Technical Memorandum – Victoria Cross ISD, SSSA Traffic and Green Travel Plan – ADDENDUM

Date:	21 May 2020
To:	Sydney Coordination Office
Cc:	Department of Planning, Industry and Environment Michael James (LendLease) Lulu Woods (Lendlease) Johanna Turnbull (LendLease) Greta King (LendLease) Stephen Canty (ArcMac)
From:	Nicole Vukic (ArcMac)
Reference Document Numbers:	SMCSWSVO-LLC-SVC-TI-REP-000001, SMCSWSVO-LLC-SVC-TI-REP-000002

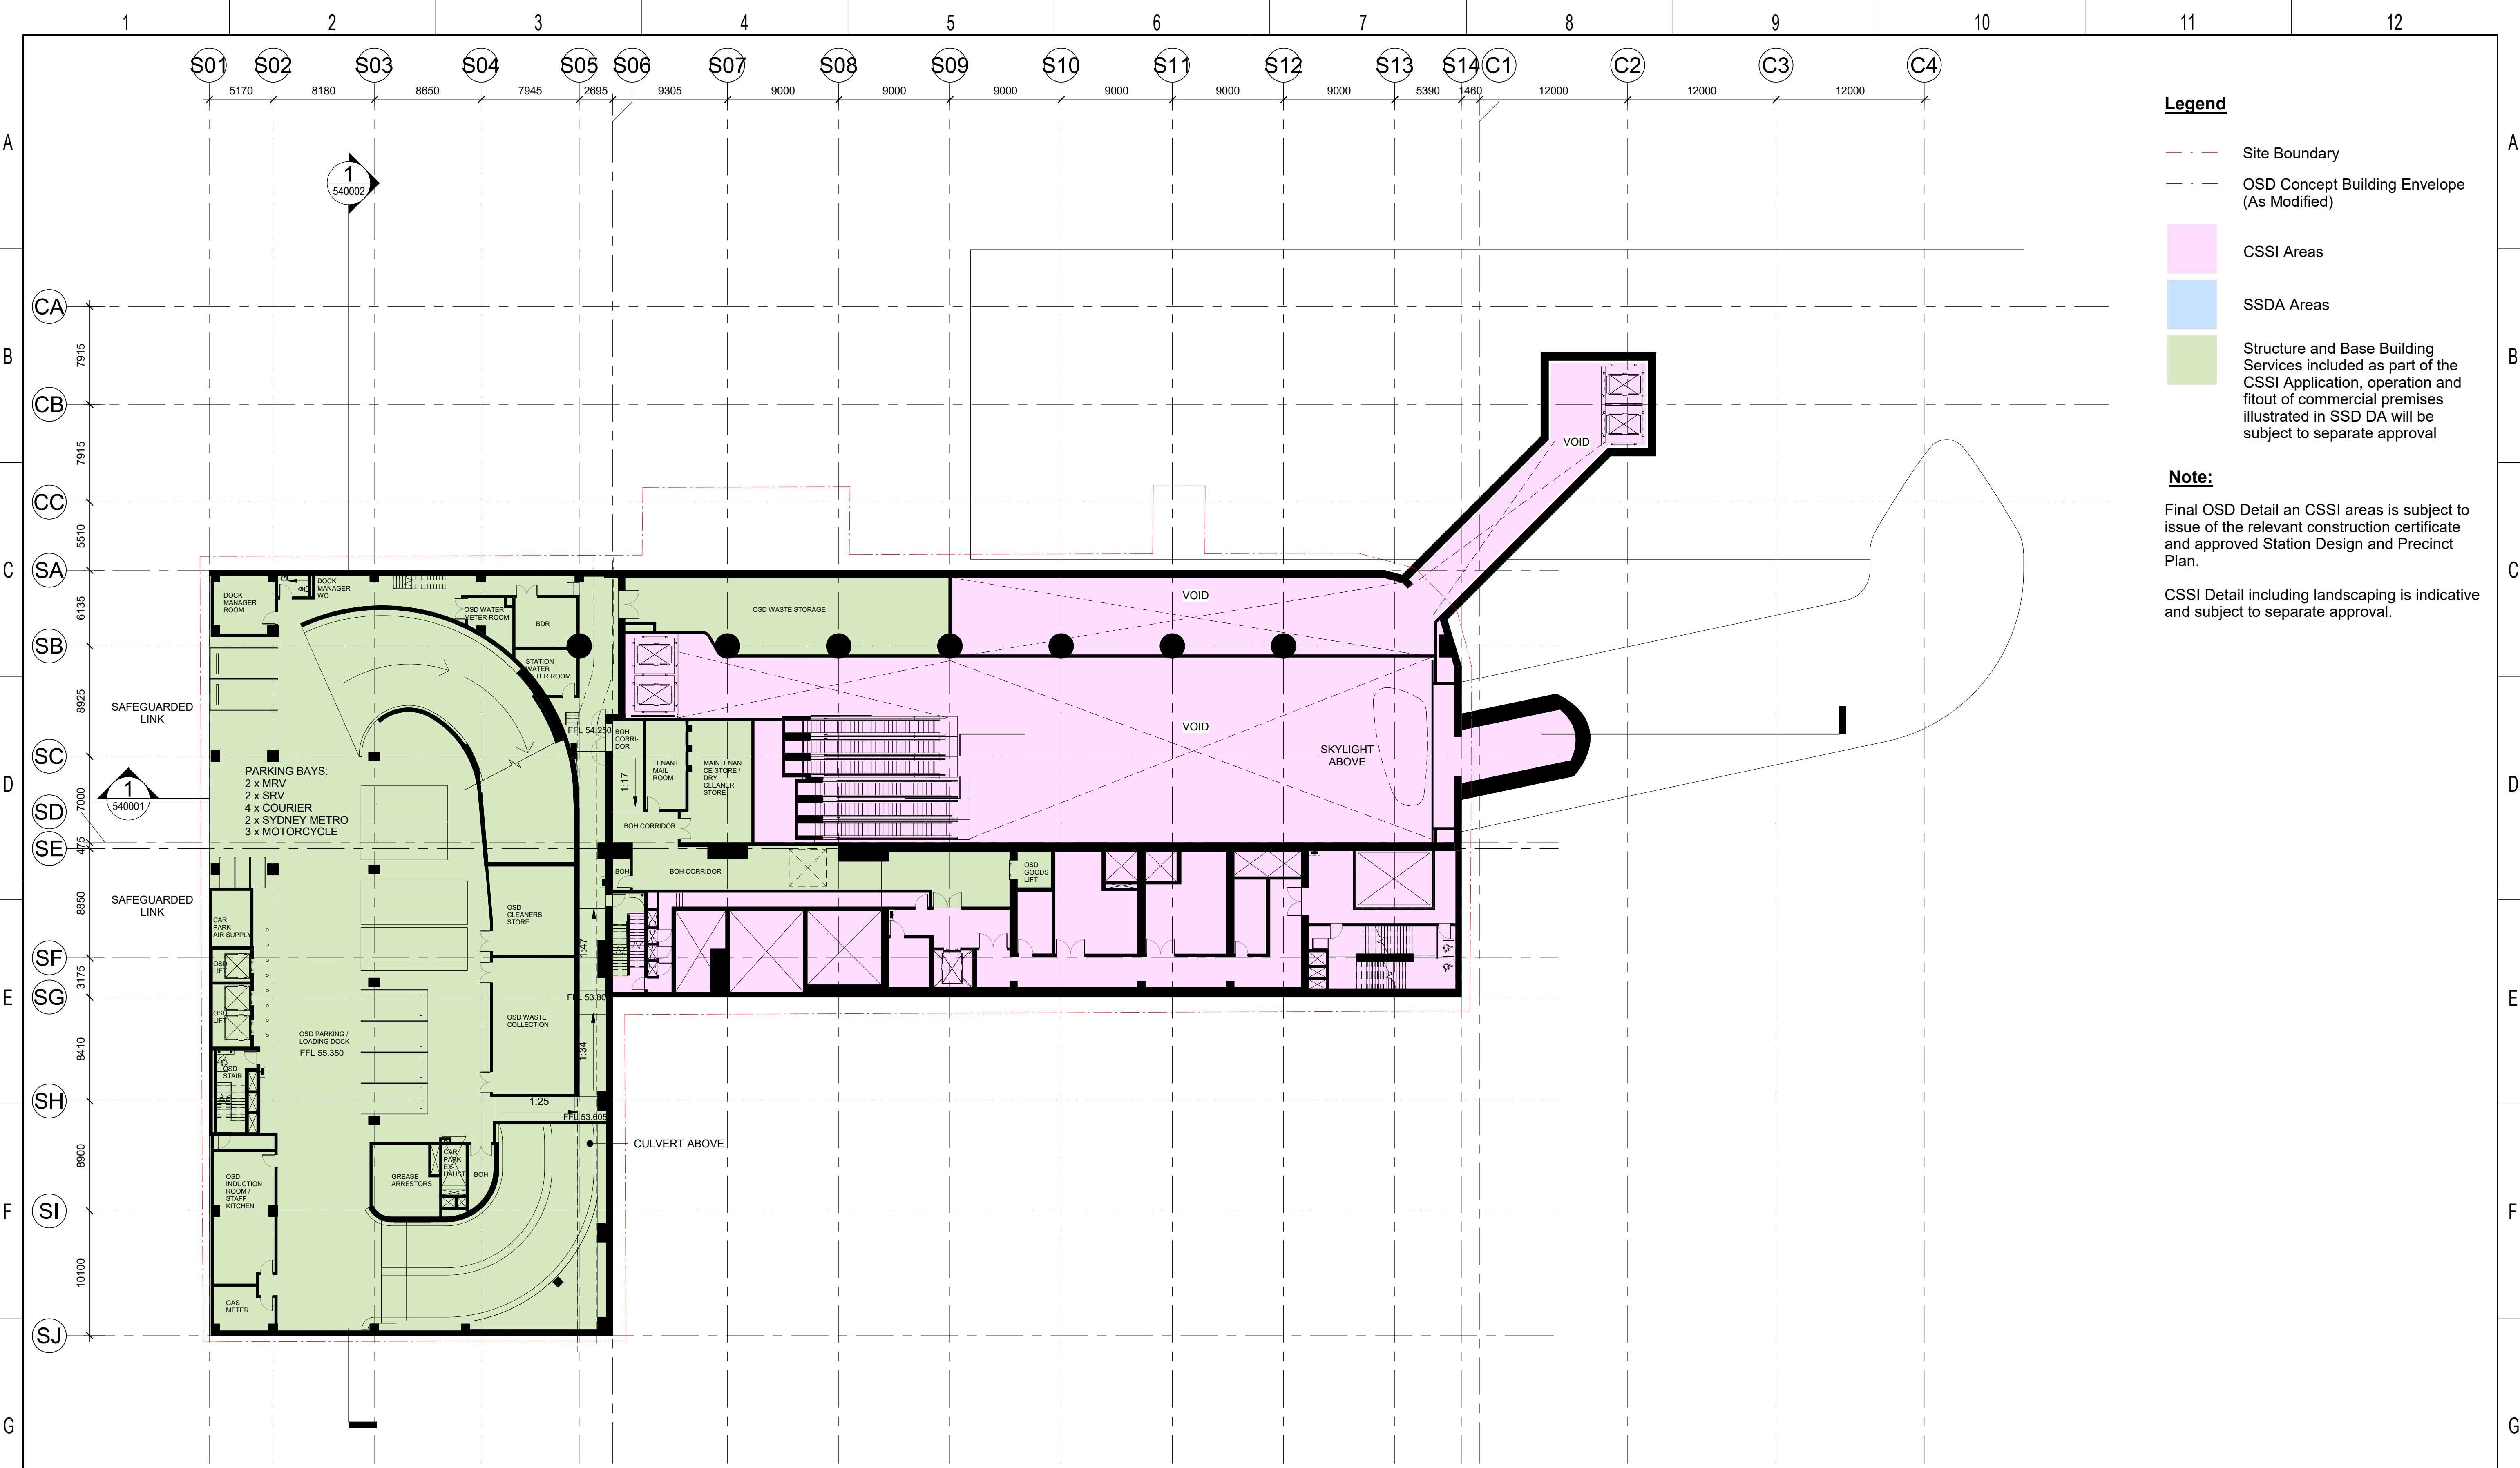
In response to concerns raised by SCO, the design has been revised since the submitted Detailed SSDA. This revised provision includes the addition of three motorbike/ bicycle courier bays located adjacent to the lift core and two light vehicle courier spaces in the south western corner of Basement Level 1 (refer to Figure 1).

It is noted that the additional two light vehicle courier spaces are located in front of one of the two locations of the provision for breakthrough to the MLC building. In the case that the breakthrough is implemented at some point in the future, and the basement becomes shared between the ISD and MLC, a new Loading Dock Management Plan would be prepared and implemented. If the relocation of these two spaces is required, this will be detailed in the new Loading Dock Management Plan.

The design provides a total of 13 loading bays, comprising the following breakdown:

- Two MRV bays
- Two SRV bays
- Four courier bays
- Two Sydney Metro bays
- Three motorbike/ bicycle courier bays.
